Re: Canal Plaza Hotel / Site Plan Submission

MEMORANDUM

TO: Greg Shinberg, Shinberg Consulting
CC: Timothy Hart & Patrick Costin, Canal 5 Studios
FROM: Denise Cameron, PE
DATE: October 22, 2012
RE: City of Portland Planning Board – Response to Revised Preliminary Site Plan Review Comments

Woodard & Curran has prepared the following responses to the review comments from Tom Errico, David Margolis-Pineo, Steve Bushy, Marge Schmuckal, Captain Chris Pirone and Lt. Benjamin Wallace Jr. on the Canal Plaza Hotel Final Level III Site Plan Application submitted on October 2, 2012. The peer reviewer's original comments are provided in *italics* and status update comments are provided in **bold italics**. Woodard & Curran's responses are provided in **bold blue**.

**C-200**

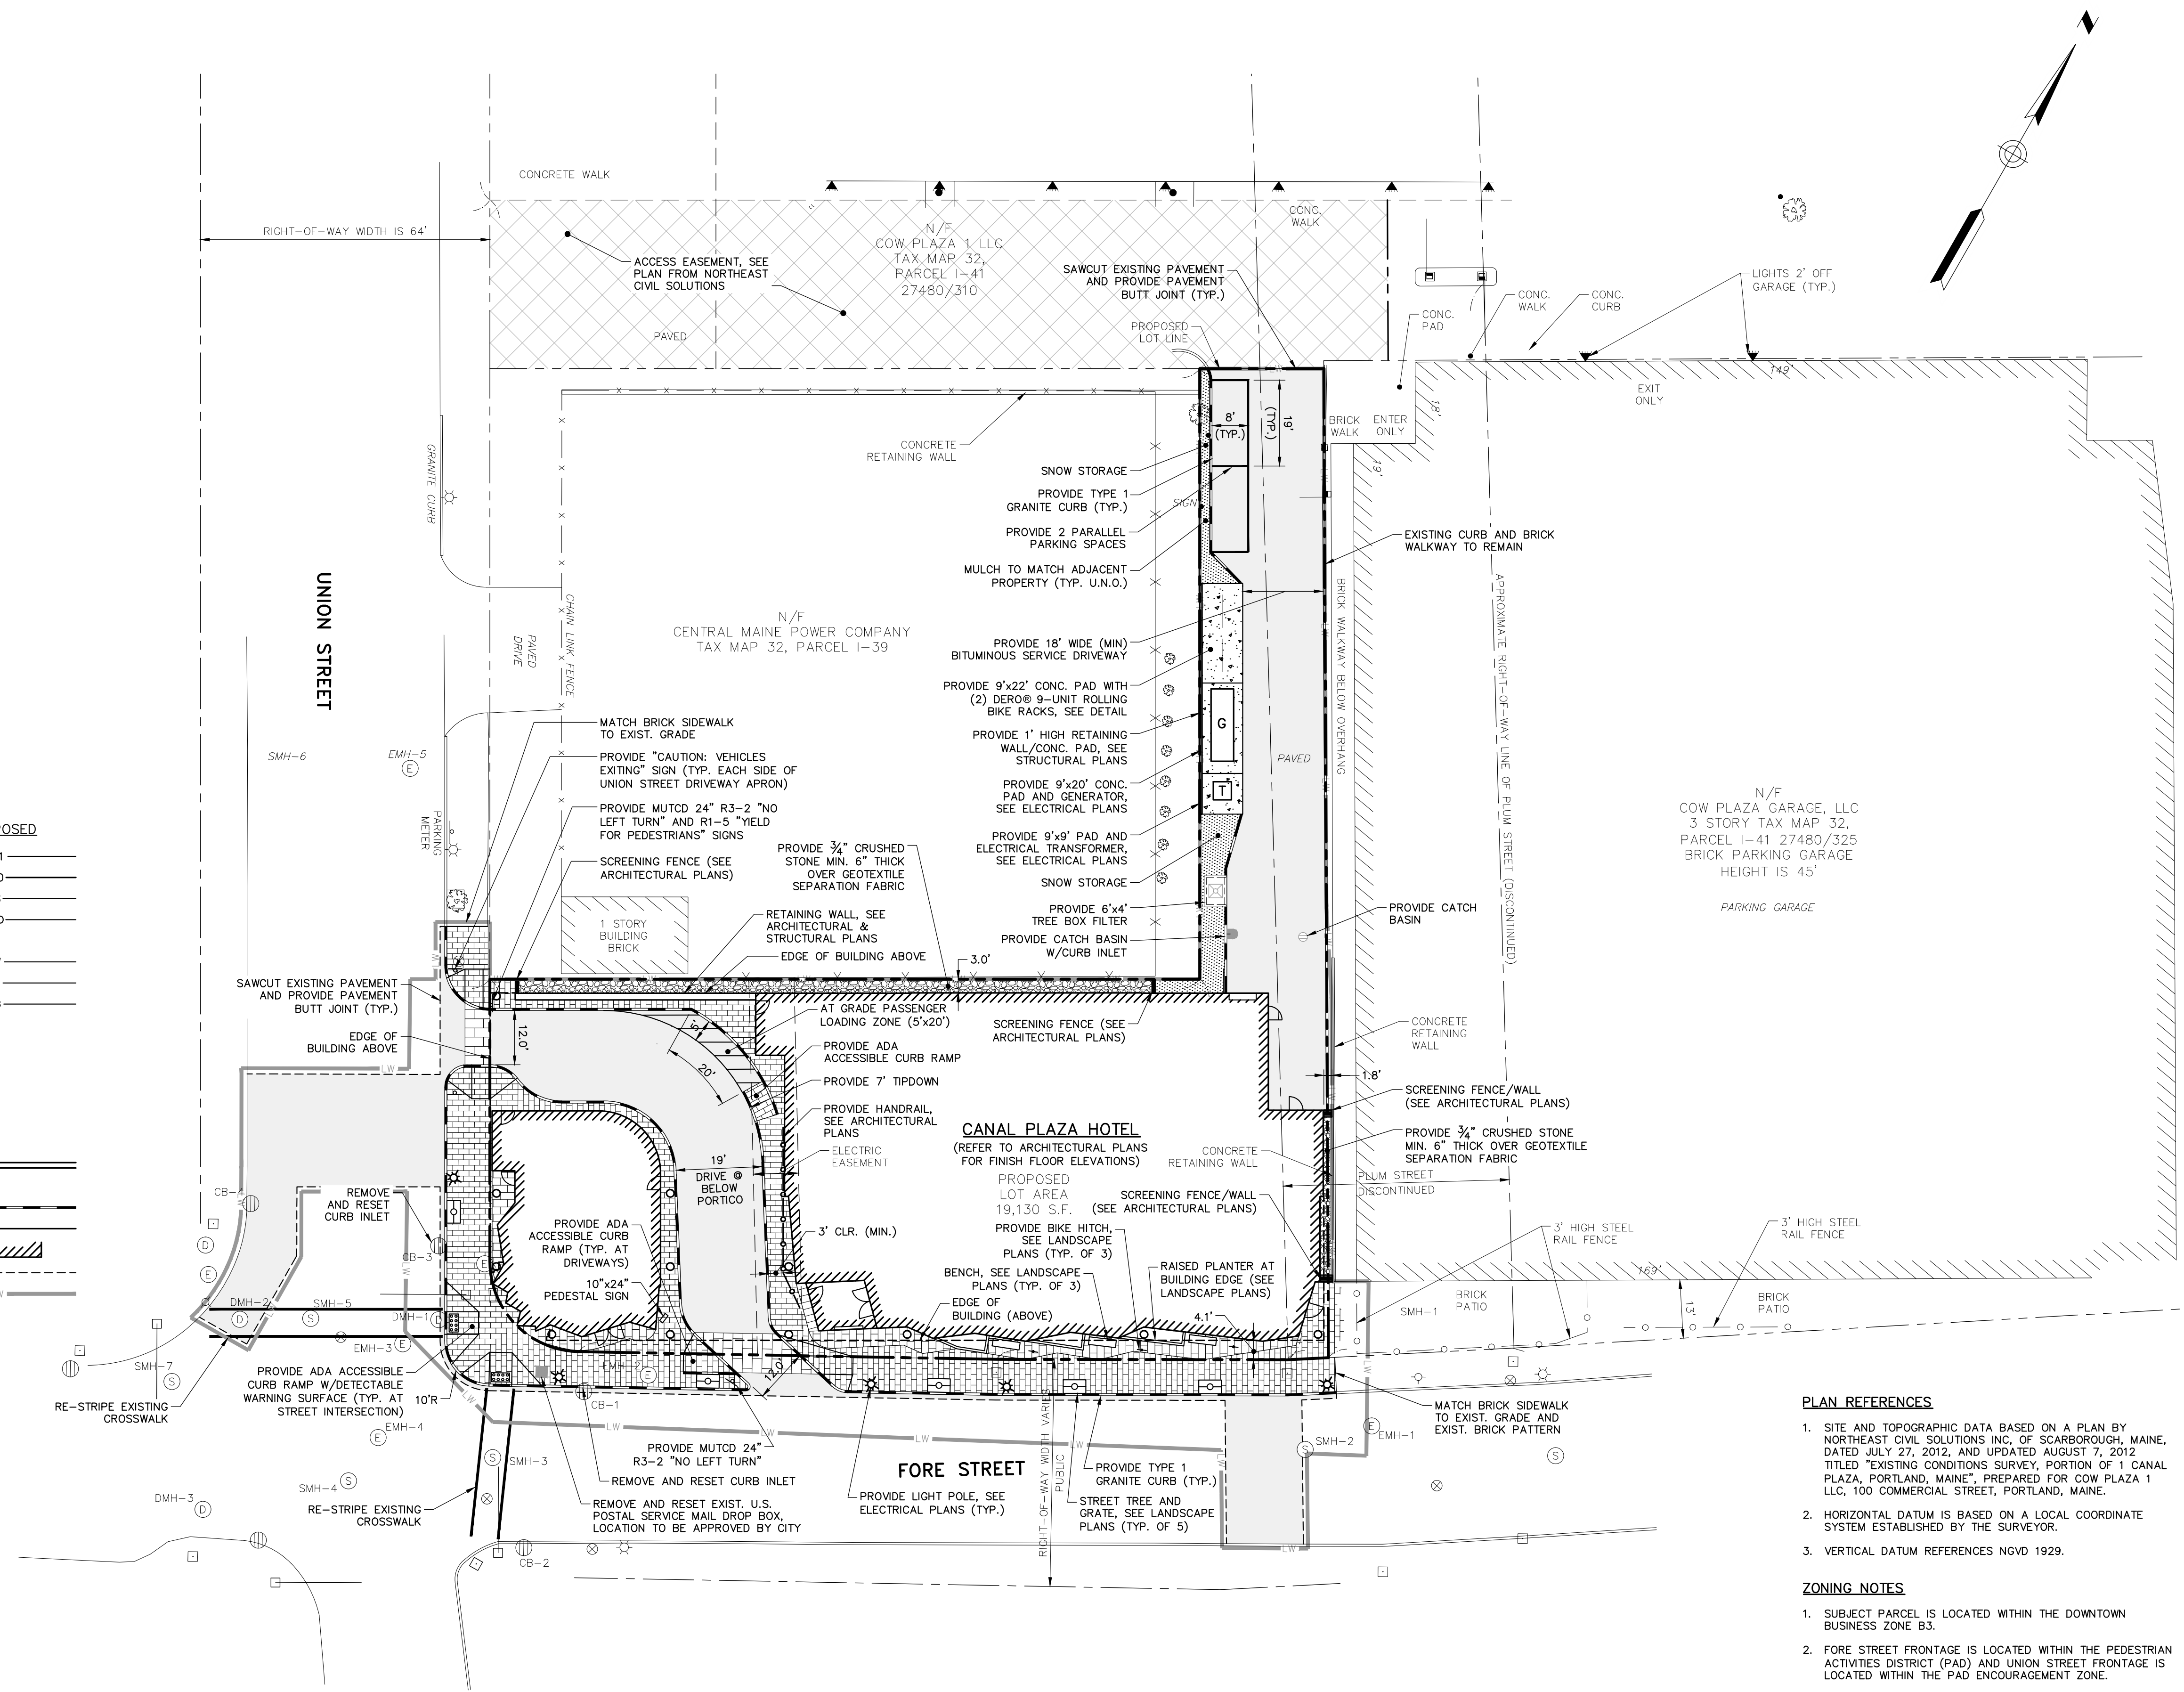
12. *9/5 Comment: The applicant will be responsible for design and implementation of signal equipment modifications on the corner of the Union Street/Fore Street intersection (in conjunction with changes on the corner). In addition, other signal improvements will be required to ensure the signal meets current standards and is upgraded such that it is functioning as efficiently as possible. I will define the recommendations in the future.*

10/2 Status Update: The City requests the following signal modifications.

- **The controller cabinet should be relocated to the northwest corner of the intersection.**
- **A new mast arm shall be installed on the corner of the project and shall include all new equipment.**
- **All pedestrian heads and push buttons at the intersection shall be upgraded.**

Note 14 of Sheet C-200 has been added at the request of the Department of Public Services requiring Contractor to "Coordinate traffic control box relocation well in

advance of work with City of Portland Traffic Engineer Jeremiah Bartlett (207)-632-1062” (See DPS Review Comment, Item #8).

Please note, the work to reduce the radius of the intersection at Fore & Union Streets is being performed at the request of the City, and there will be no impacts to the traffic signal mast arm. The applicant will not relocate the cabinet across the street to the northwest corner (See Page 5, Question 8) and is not proposing to make the other requested modifications.

**SITE PLAN**

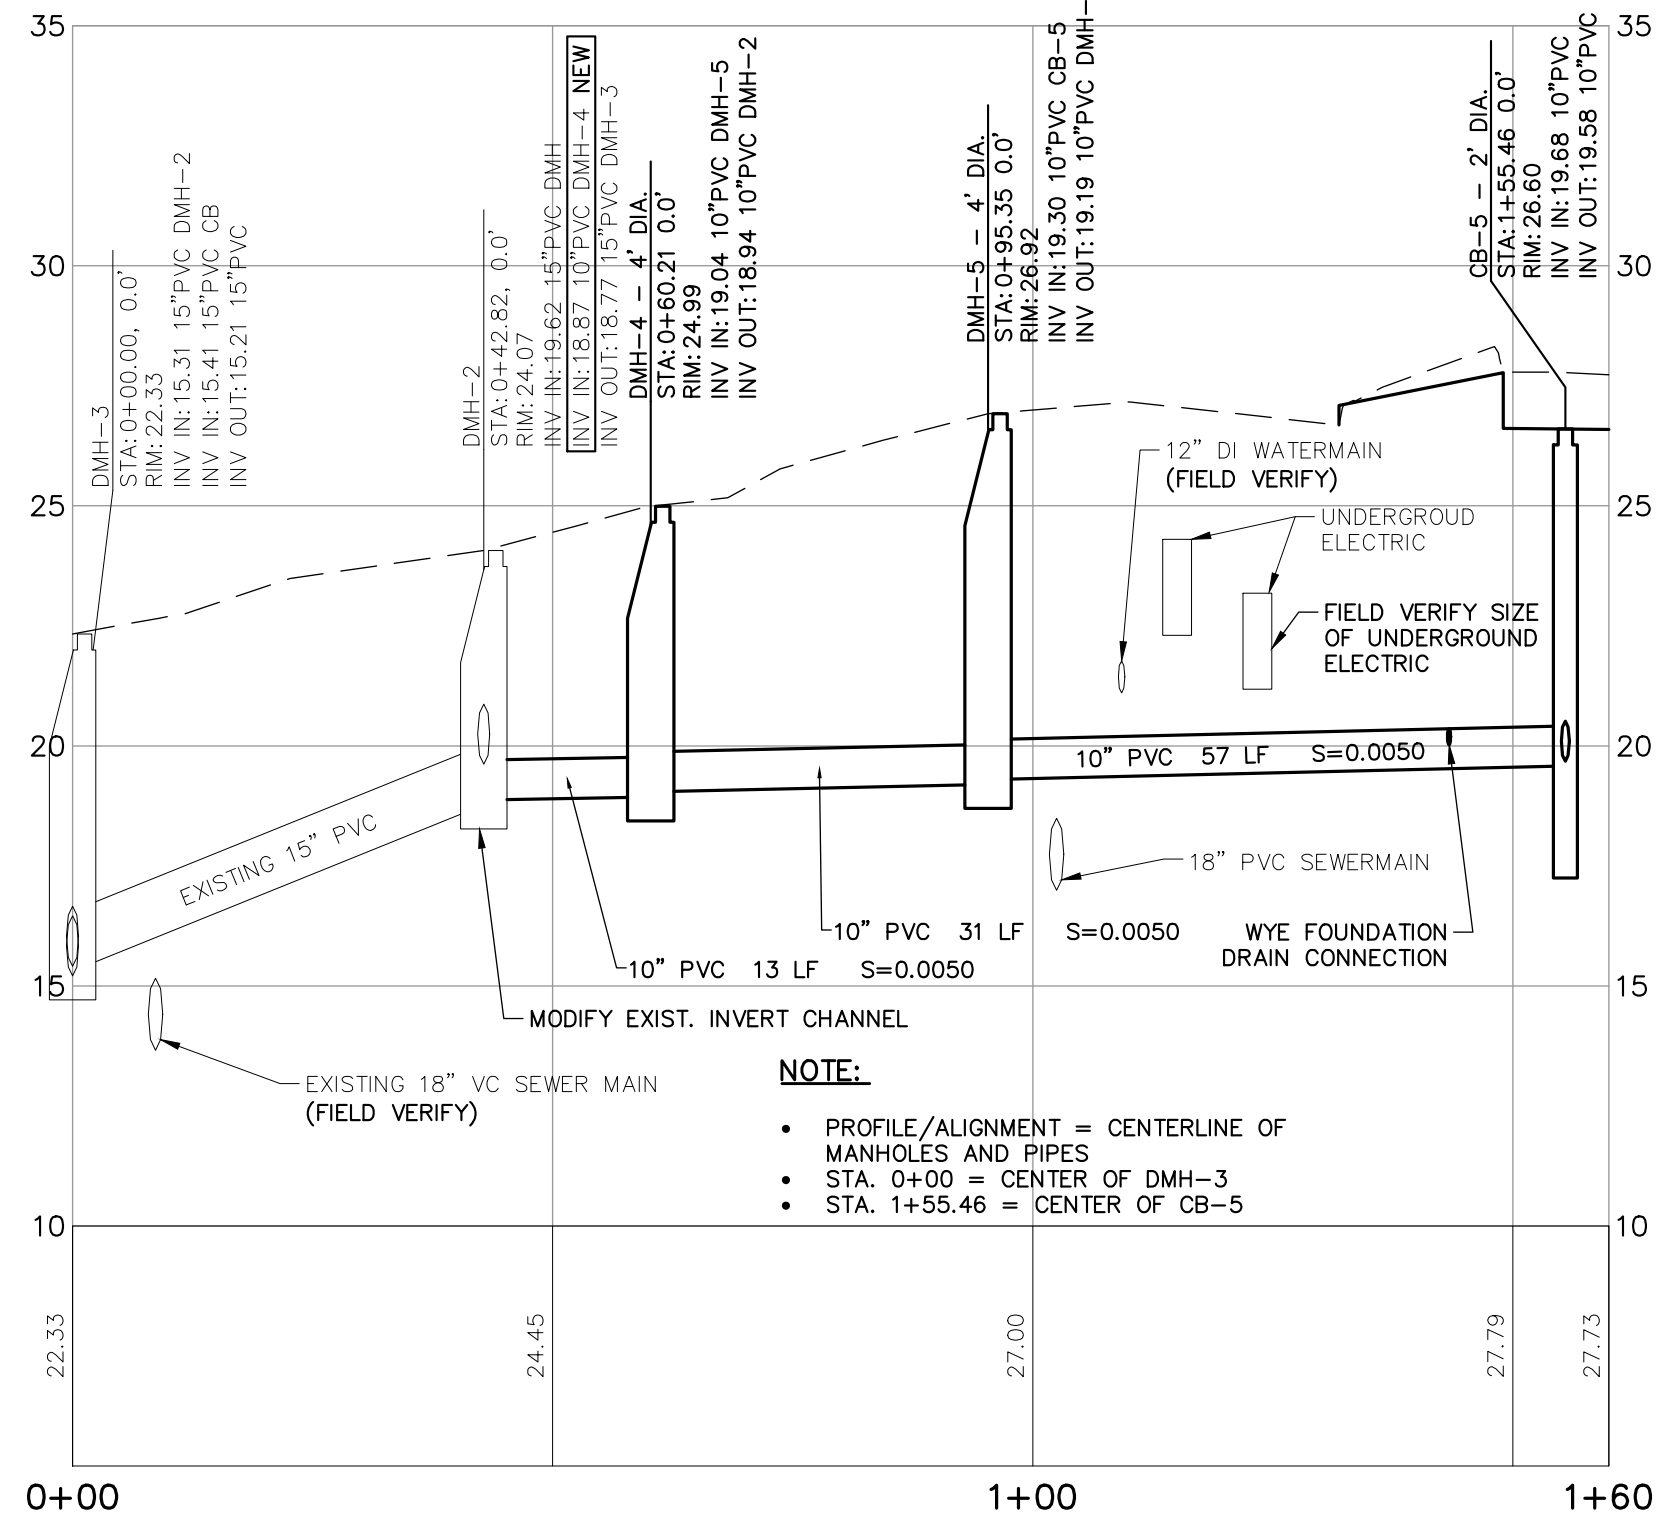
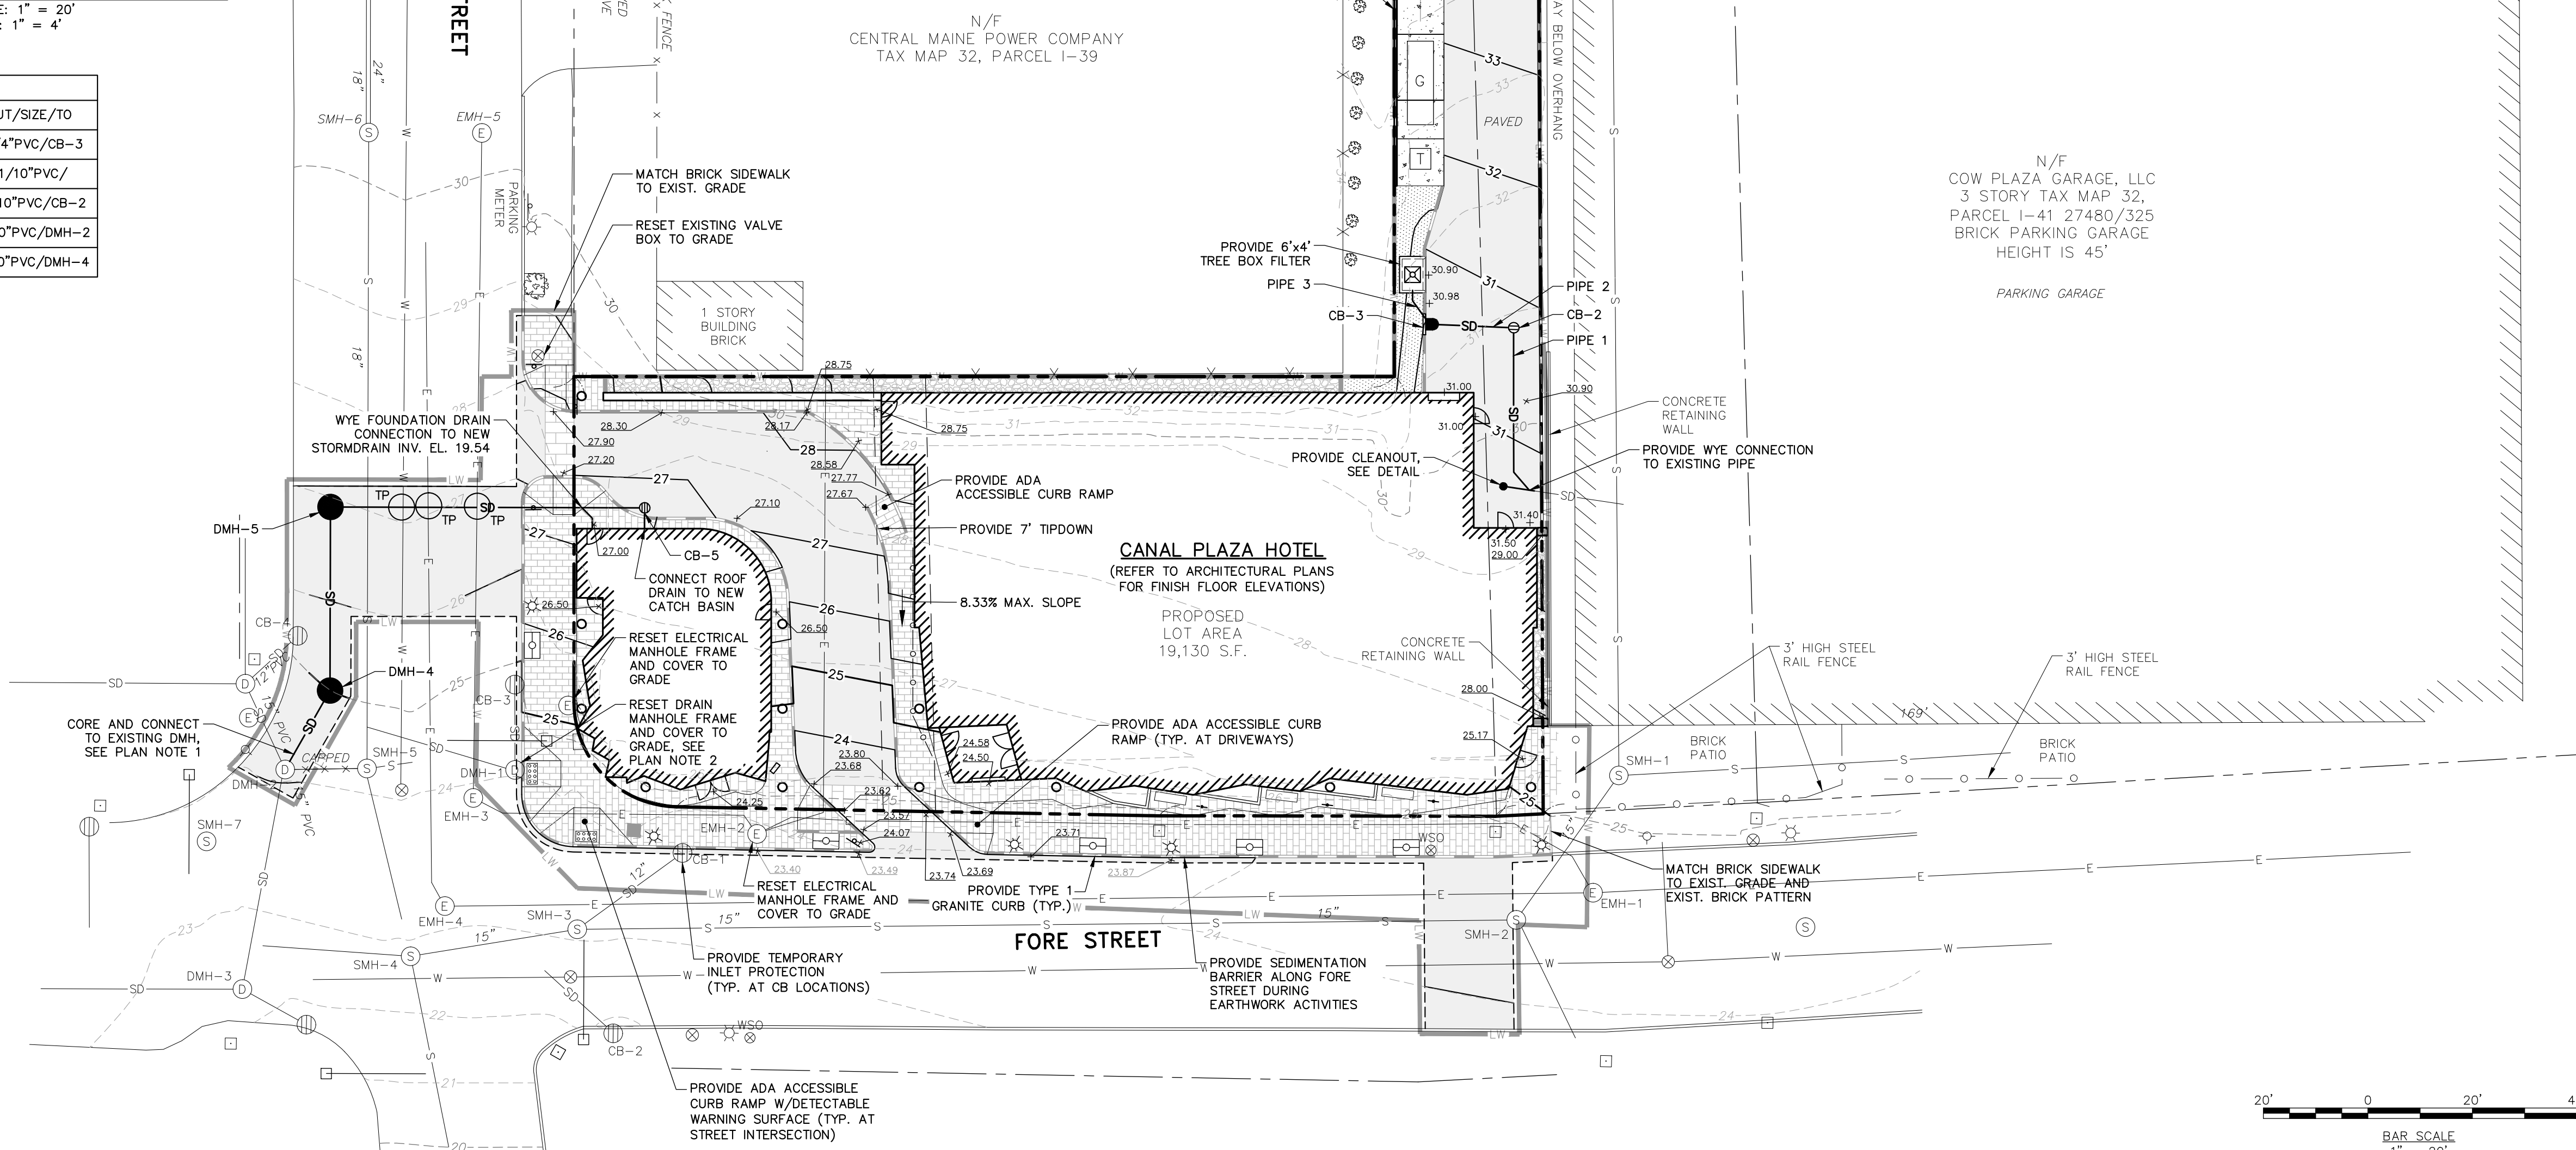
3. *9/5 Comment: It is my suggestion that left-turn movements entering the hotel on Fore Street be prohibited due to long vehicle queues on Fore Street (from the Union Street traffic signal). In my professional opinion signage alone will not be sufficient treatment for enforcing this prohibition. The applicant should investigate geometric alignment changes for the driveway and possible treatments on Fore Street for restricting left-turn entry movements.*

10/2 Status Update: Status: The applicant has revised the geometry of the driveway entrance to discouraged left-turn entry movements. Given area conditions, this change seems reasonable. I would also suggest that regulatory signs noting the left-turn prohibition be installed.

Sheet C-201 has been revised to include a “No Left Turn” sign at the Fore Street driveway.
